Our Case Number: ABP-308208-20

Re: Construct electricity substation compound, to replace substation already granted permission under PL04.219620 (05/5907) and extended under 11/6605. Electricity substation layout includes 3 no. control buildings, associated electrical plant and equipment, security fencing and ancillary works. A 10 year permission is sought
Barnadivane, Kneevs, Terelton, Co. Cork

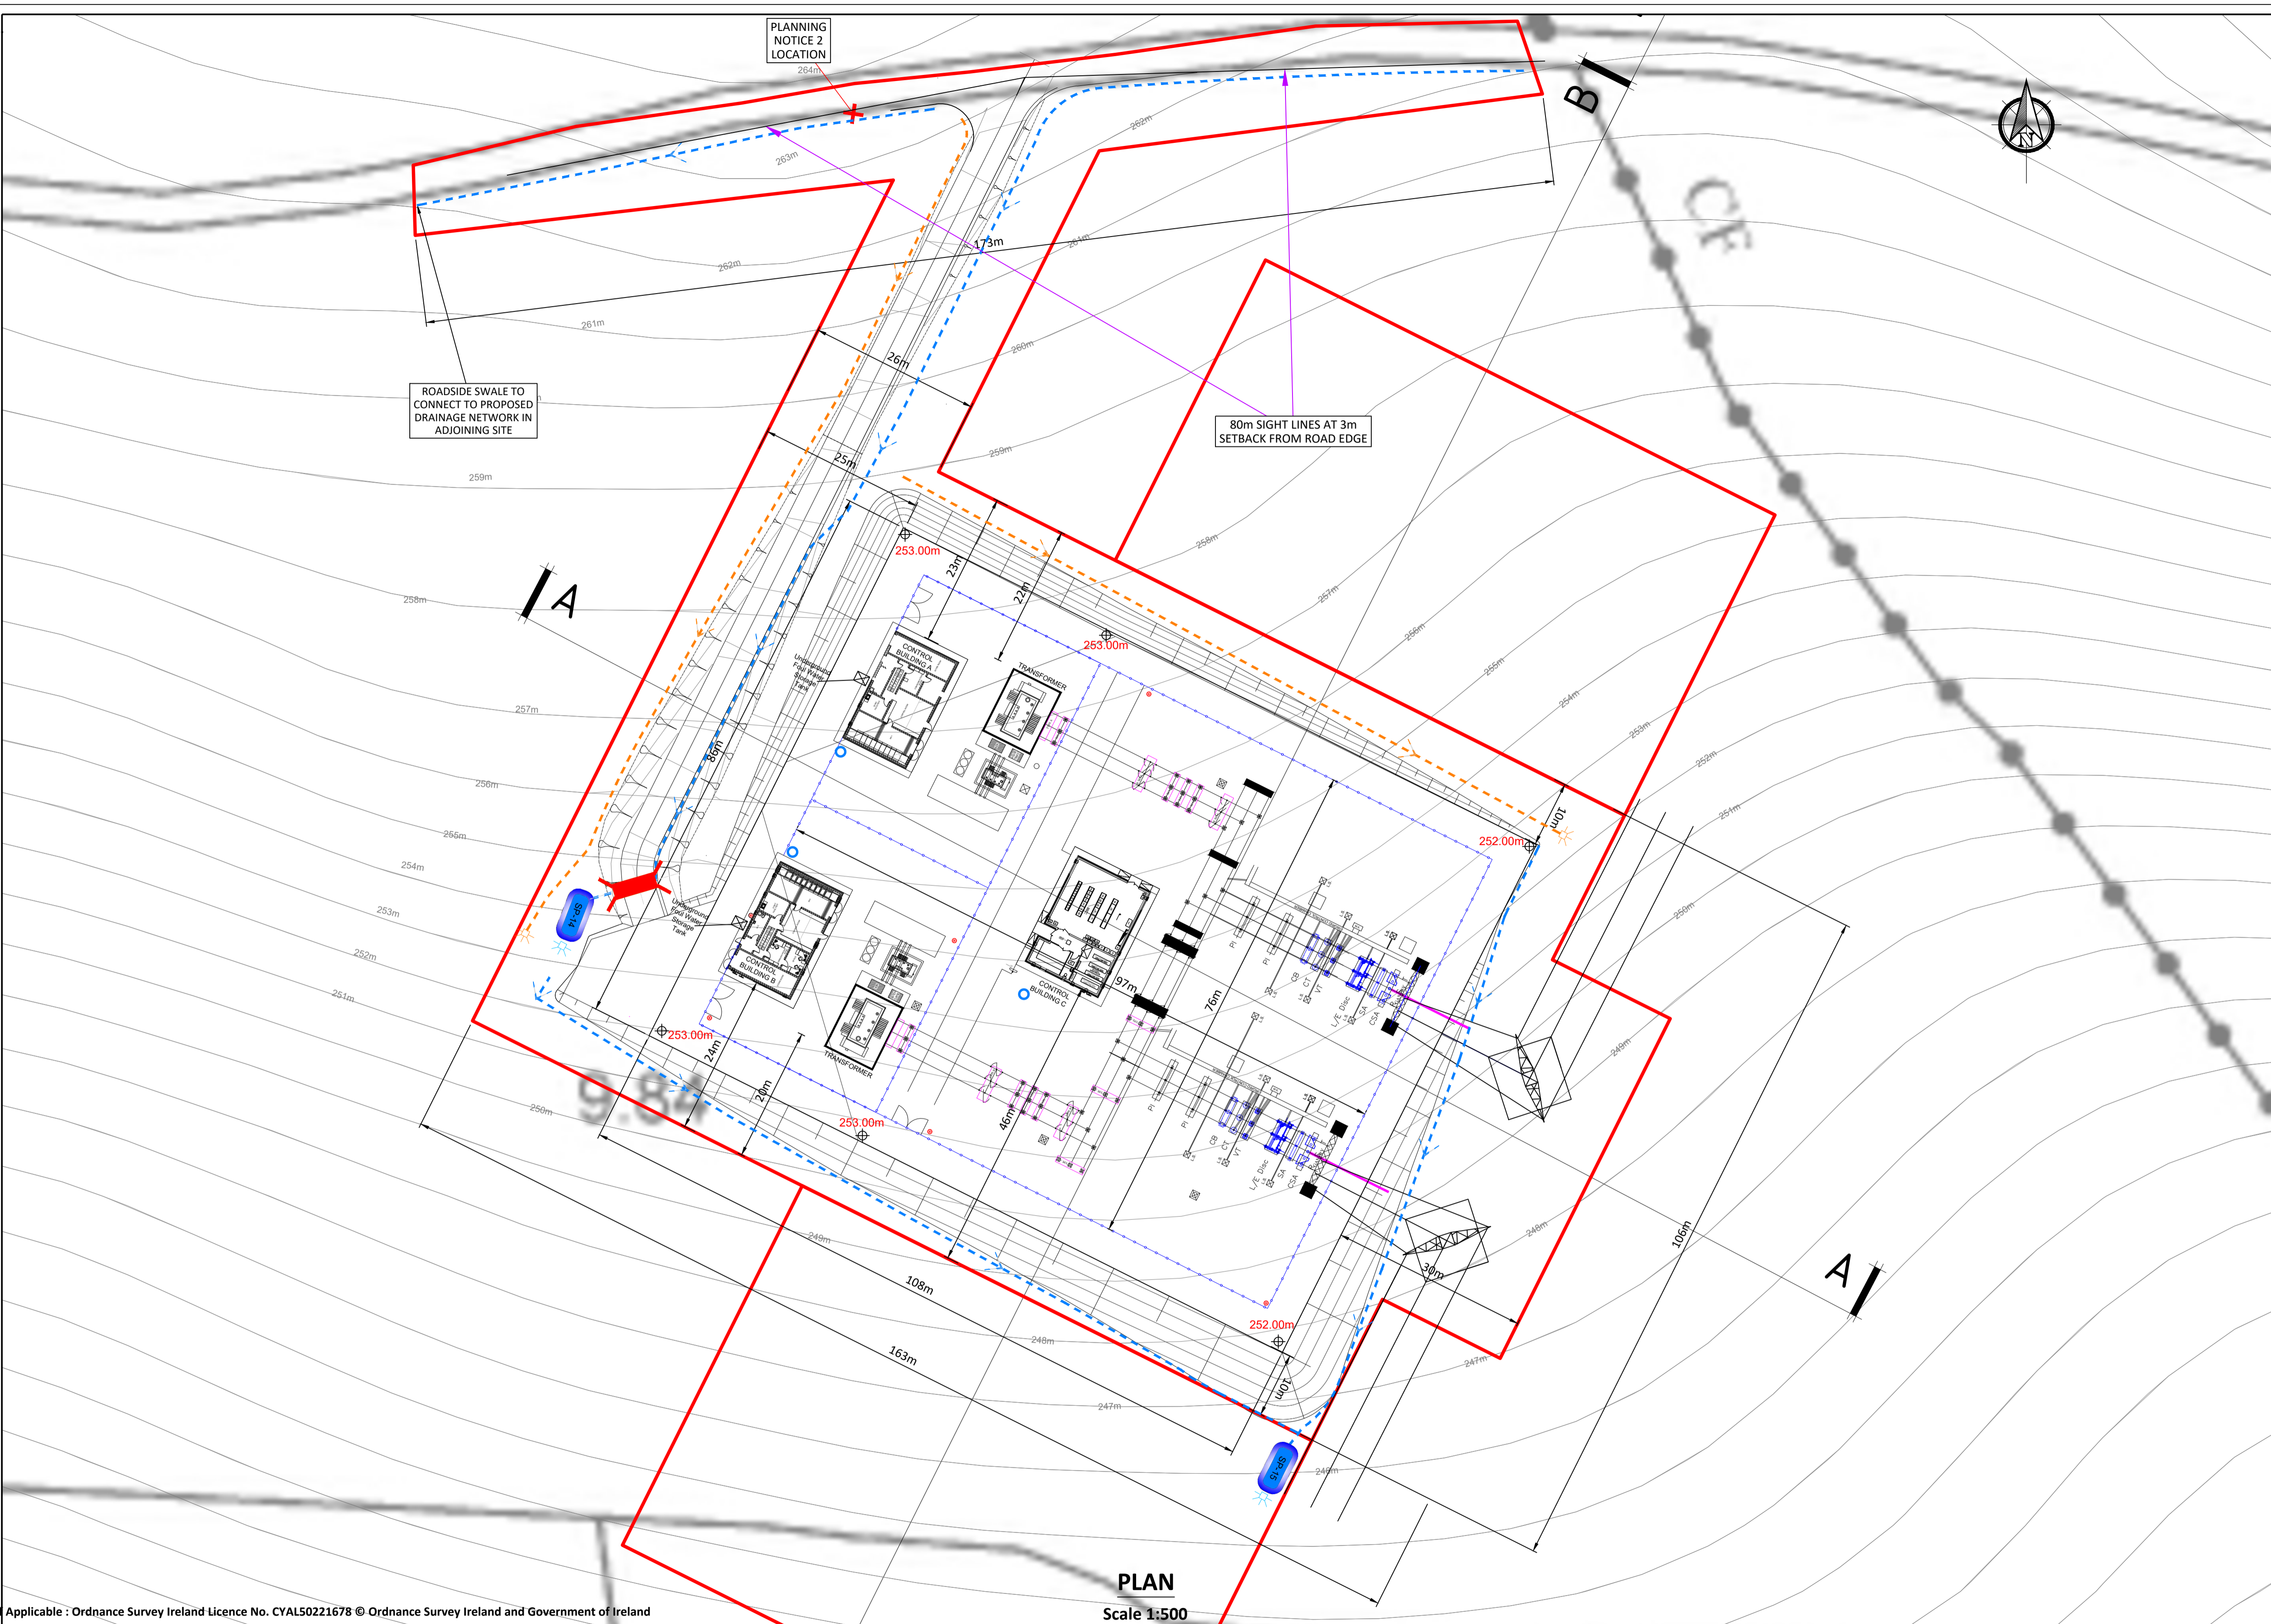
4. Regarding landscaping of the substation site, it is considered that this should incorporate dense planting on earthen berms where possible. You are requested to provide a detailed plan, which may include lands outside the site boundary, for the purpose of providing screening landscaping with berms. Any required letter of consent should be provided and the relevant lands should be outlined in blue on the application documentation.
